Recommendation Report for Planning Permission for Works or Extension to a Dwelling

REF NO: P/88/20/HH

LOCATION: 48 Greenways
Pagham
PO21 4QE

PROPOSAL: Demolition of conservatory.Erection of single storey rear extension.

ROOF PLAN

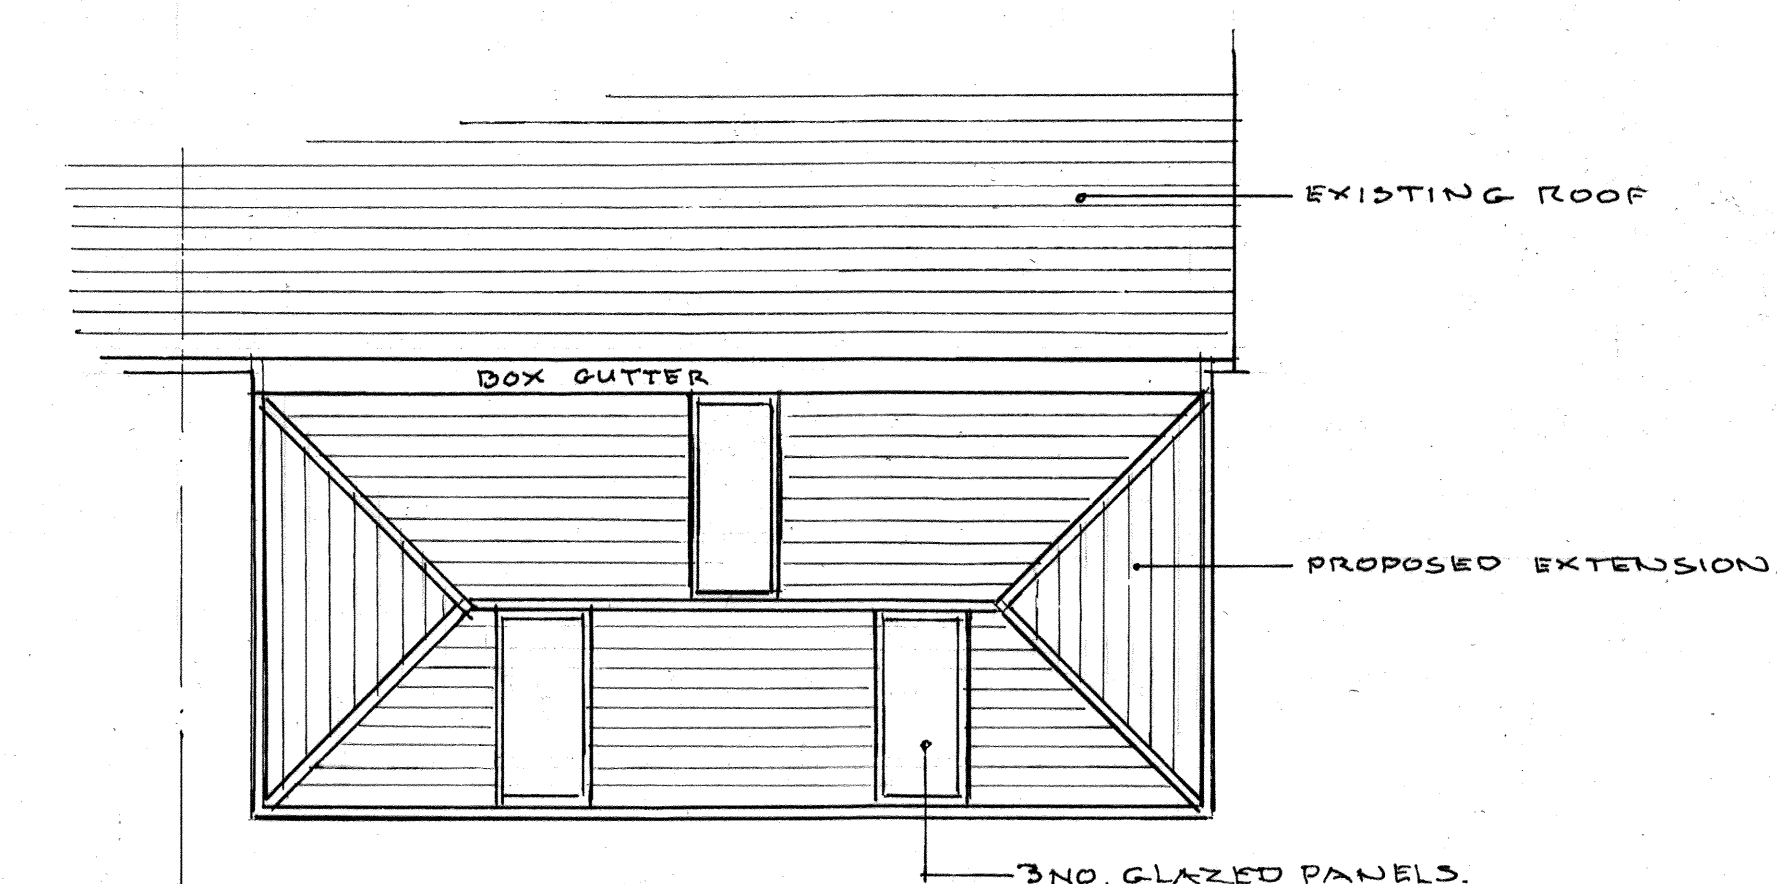
The property seeks to replace an existing conservatory on the eastern elevation with an extension of a similar footprint albeit approximately 700mm deeper.

The proposed extension will be 6.7m wide and 3.2m in depth, with a ridge height of 3.5m with eaves to match existing and will therefore appear subservient to the host dwelling. It is not deemed to adversely impact the spatial character of the local area, as such the design, siting and scale of the extension accord with the policies D DM1 and D DM4 of the Arun Local Plan.

The existing structure which is being replaced, has a mono-pitched roof which is 800mm lower than the proposed; although the overall height of the ridge at approximately 3.5m high is not considered to cause any undue harm to the neighbouring properties. It is felt there is sufficient space to the proposals respective boundaries, with no encroachment on the distances set from the previous structure on the proposals nearest boundary with No.46 to the South.

No additional views out of the building are proposed to those which is already achievable, the proposed 3No. rooflights will be located significantly above normal head height.
